# **KIRKLEES METROPOLITAN COUNCIL INVESTMENT & REGENERATION SERVICE**

| Reference No:         | <b>2025/62/92198/E</b>                                  |
| Site Address:         | 107, Balme Road, Cleckheaton, BD19 4EW                  |
| Description:          | Erection of two storey and single storey side extension |

Drawing Title
PROPOSED

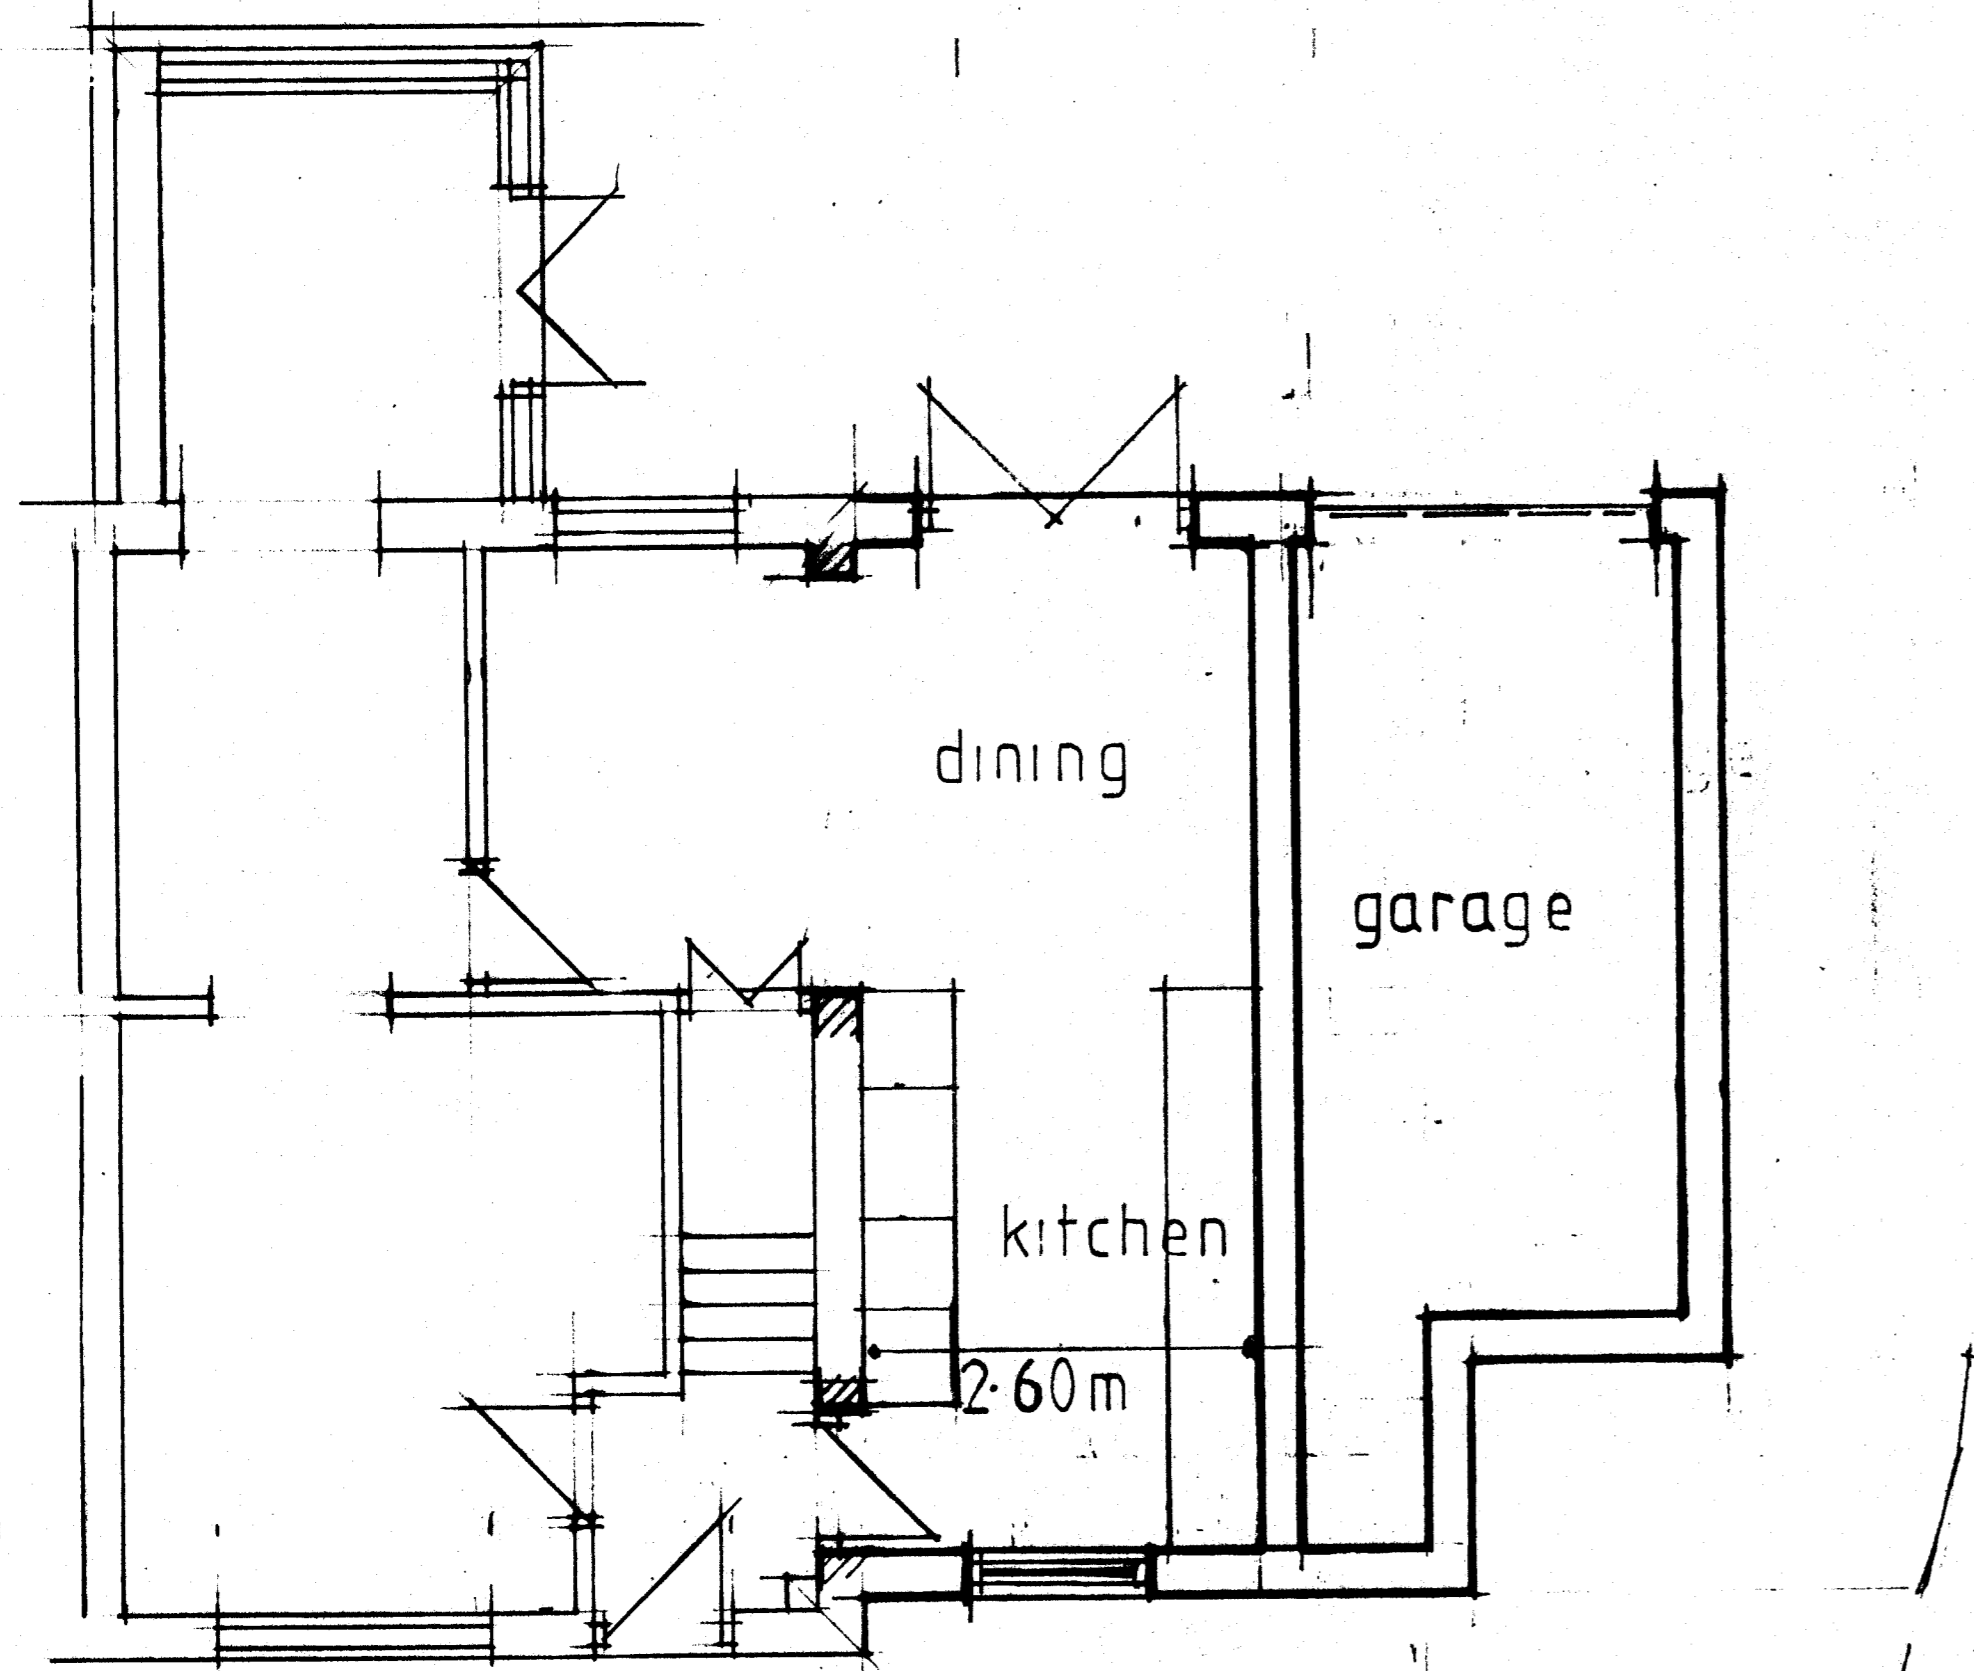
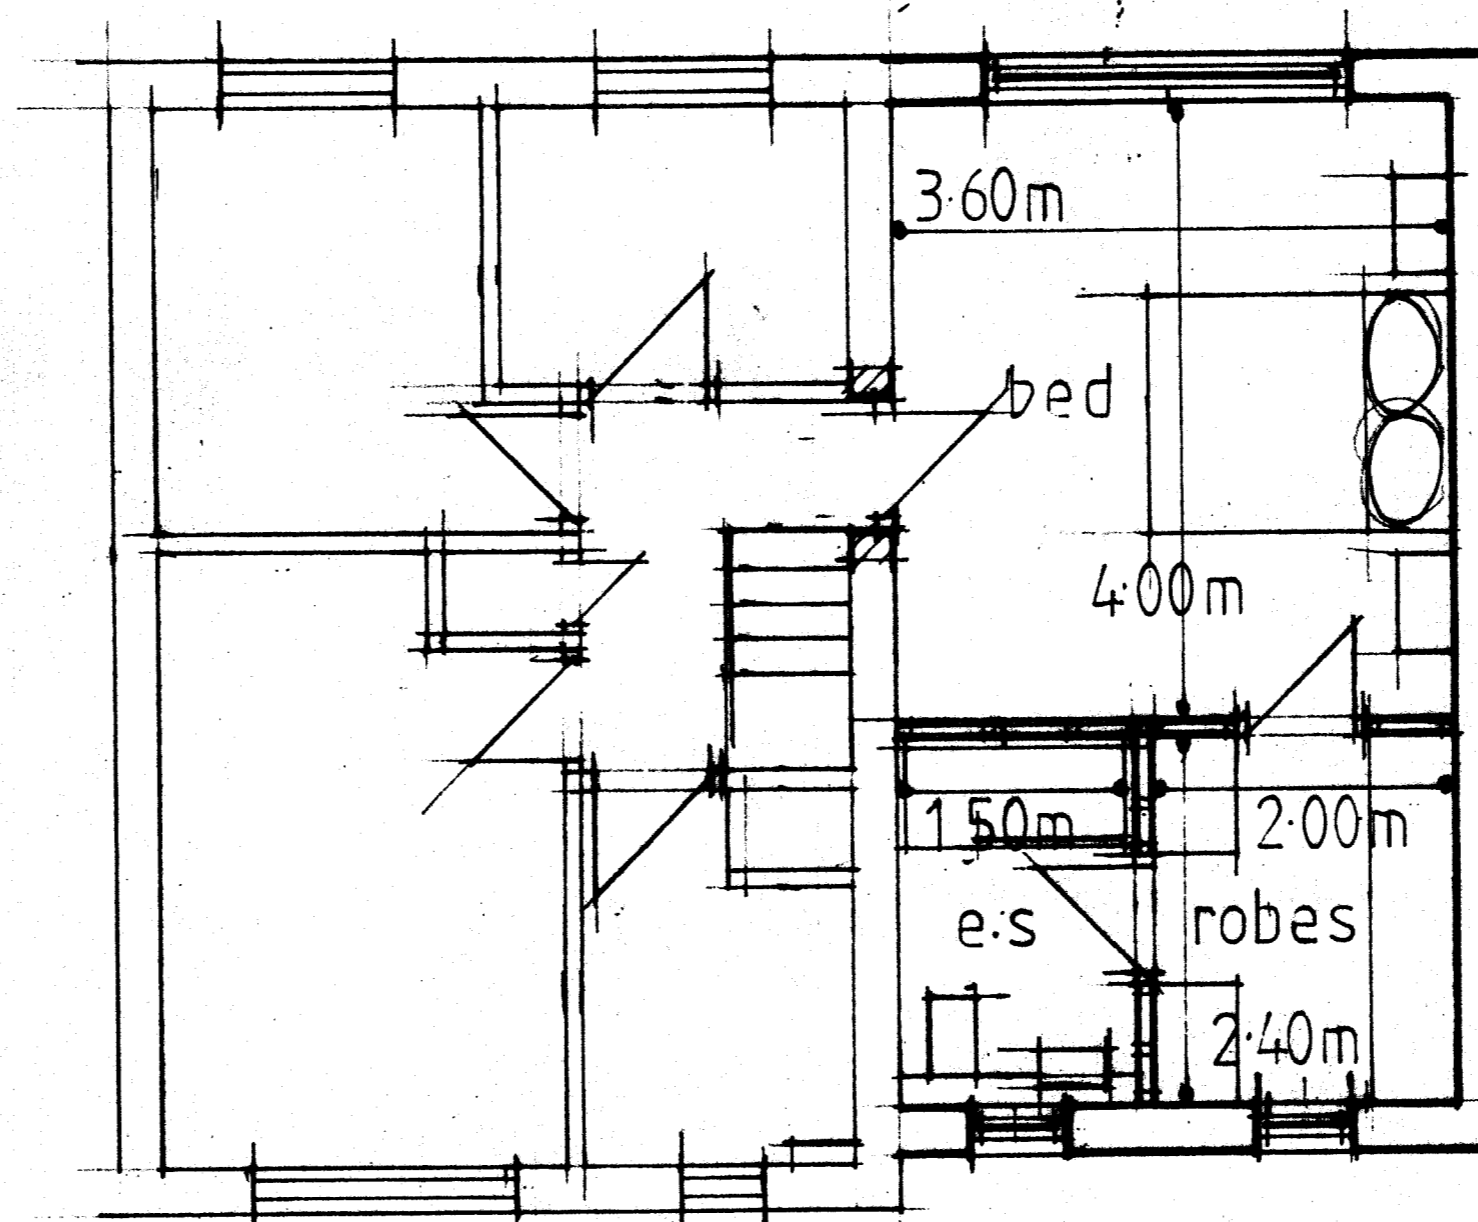
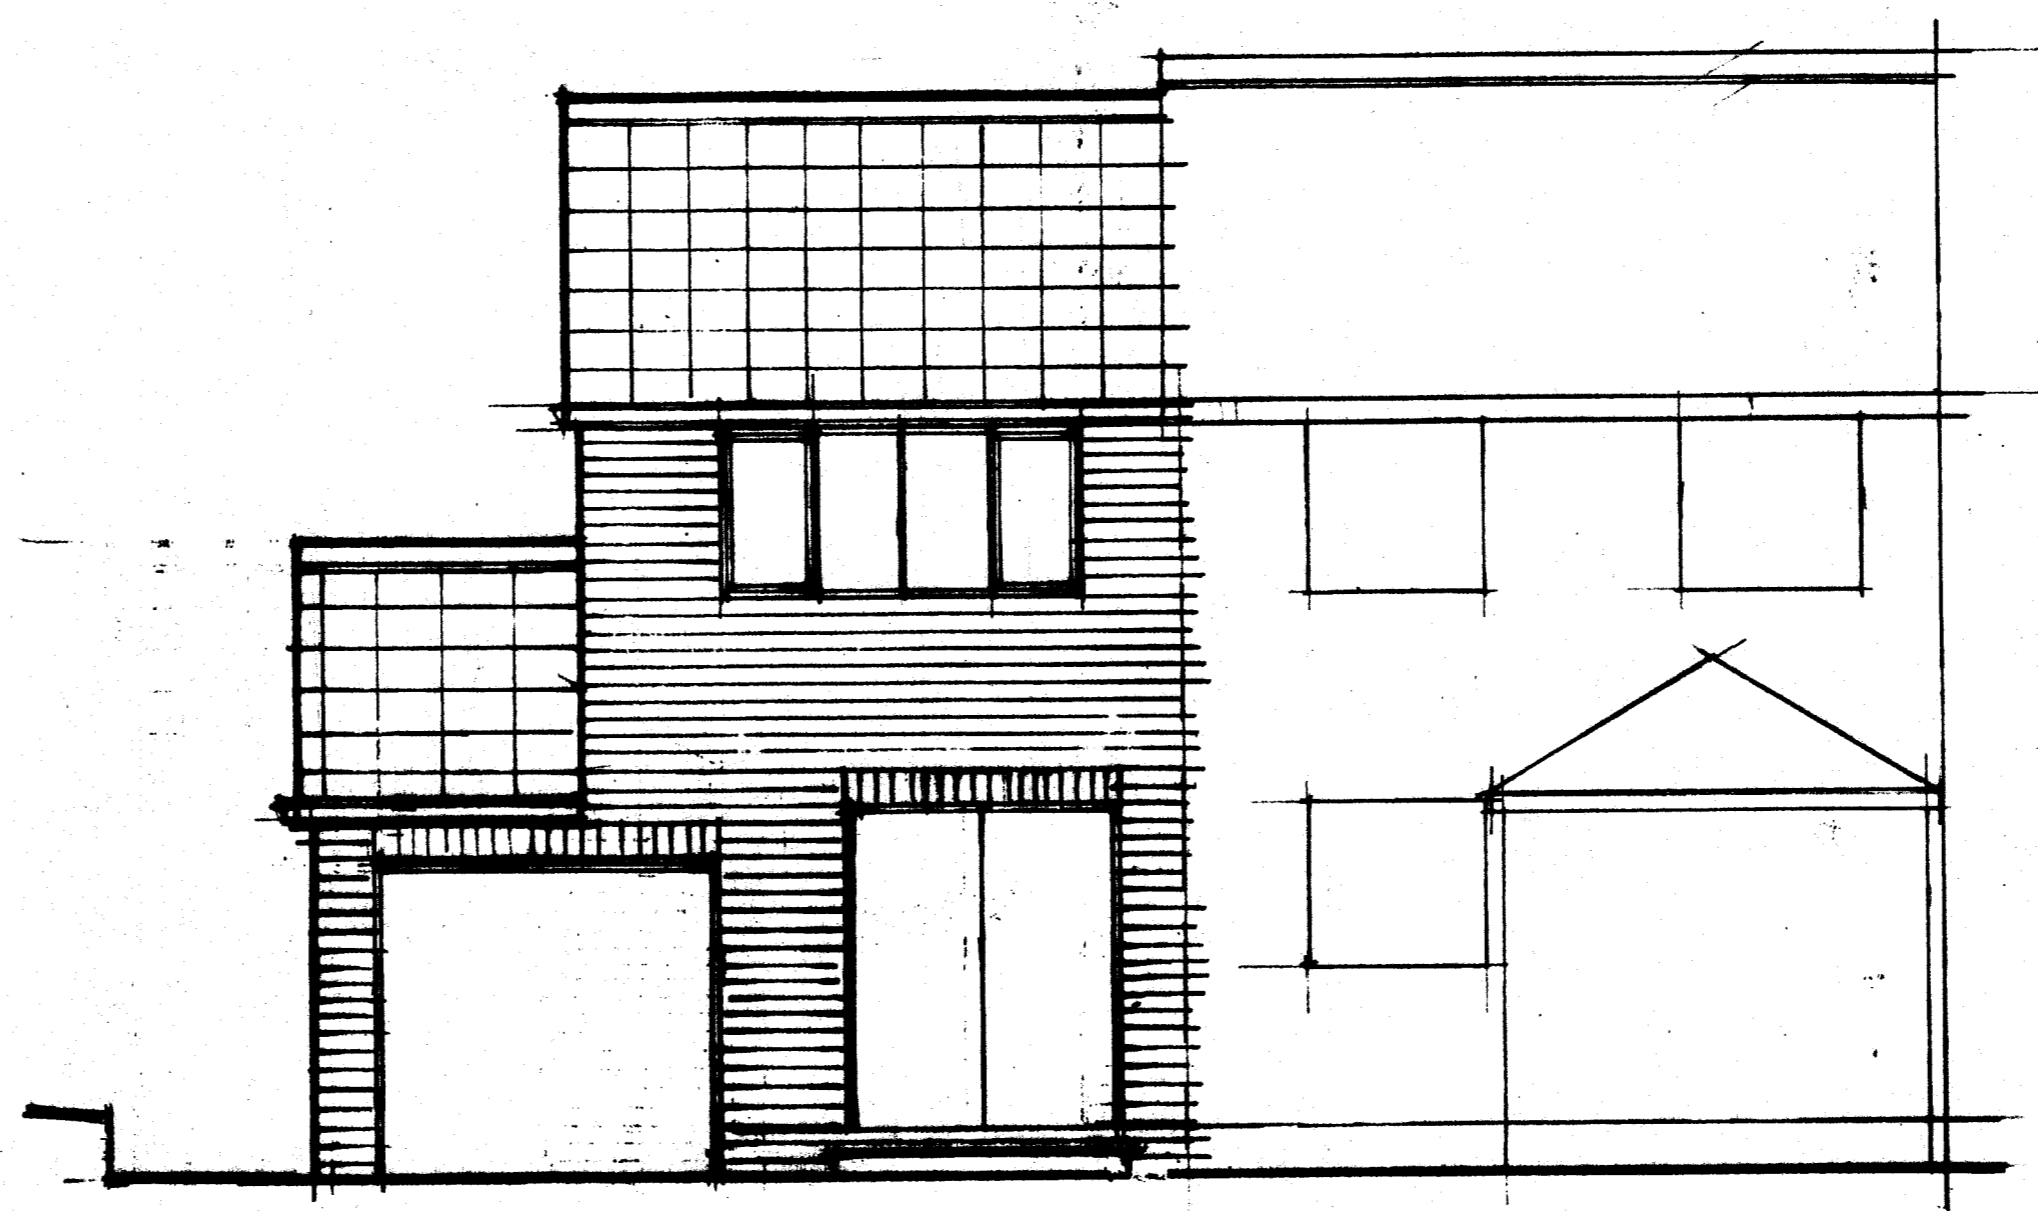
The proposals raise concerns in terms of the massing of development in the prominent position on the corner of Balme Road and Kestrel View. Amended plans have been sought and received which reduce the width, retain the garage in it existing position with roof alterations and part of the first floor over which address the concerns. As the alteration reduces the level of development, the amended plans have not been advertised.
